From: Martyn White [REDACTED]
Sent: 13 August 2021 14:46
To: Planning.Responses [REDACTED]
Cc: Amber Willard [REDACTED]
Subject: P/90/21/L

P/90/21/L

Morrells Farm Lower Bognor Road Lagness PO20 1LR

Listed building consent for the repair and repaint windows

FRONT ELEVATION
DOOR & WINDOWS TO BE REFURBISHED

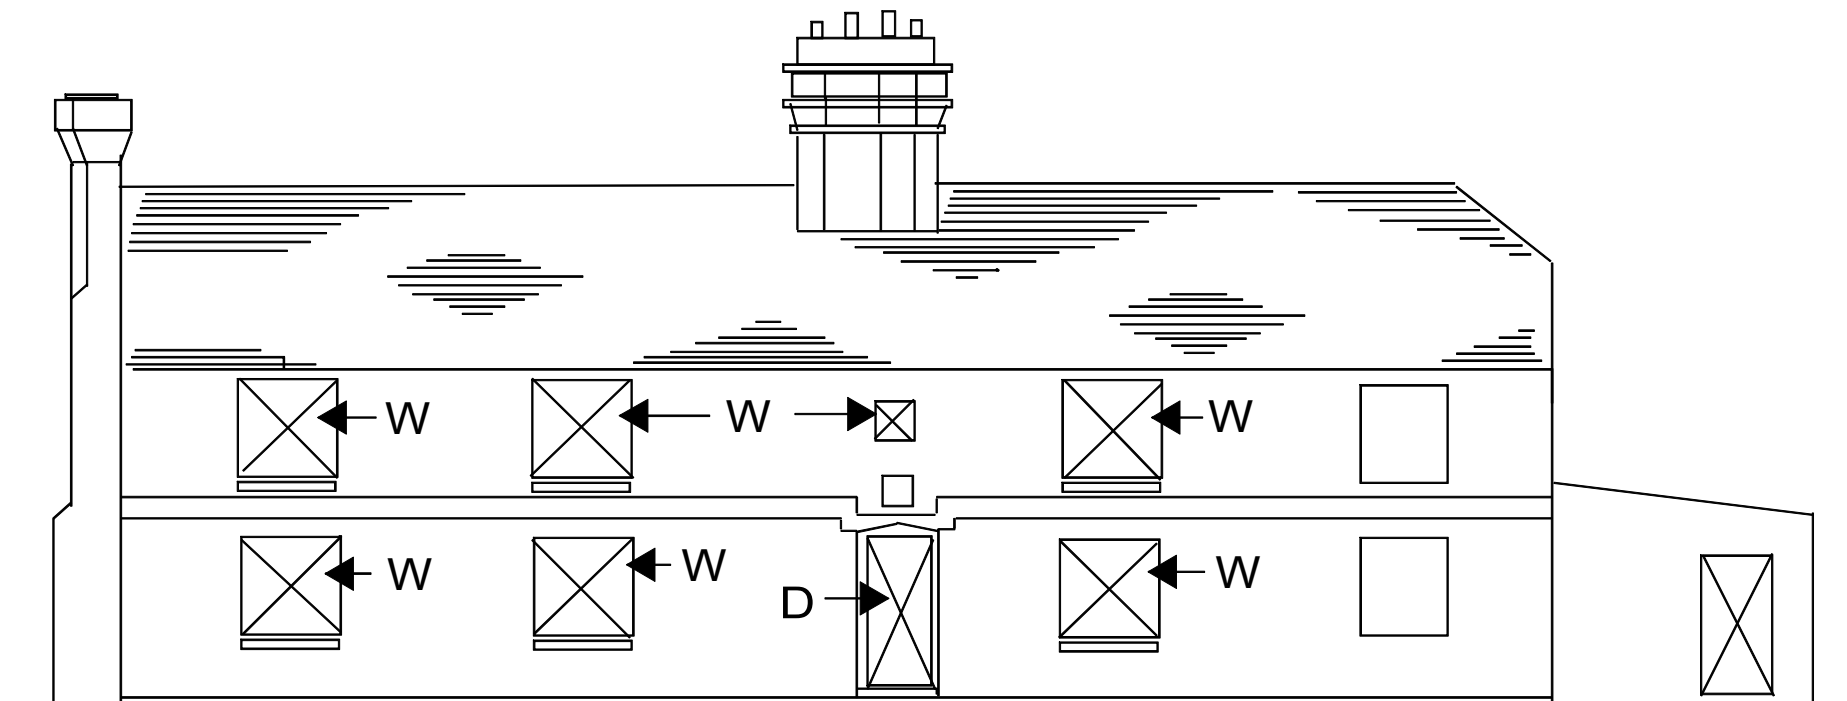
The works as described are works of repair and are acceptable, as is the proposal to introduce secondary glazing. The latter should be installed so that it can be easily removed without causing harm. It might help to understand the type and appearance of the proposed secondary glazing, just to confirm the impact they would have on the windows.

if it becomes clear when undertaking the works, that one or more of the windows are beyond repair and require complete replacement, a separate Listed Building Consent will be required.
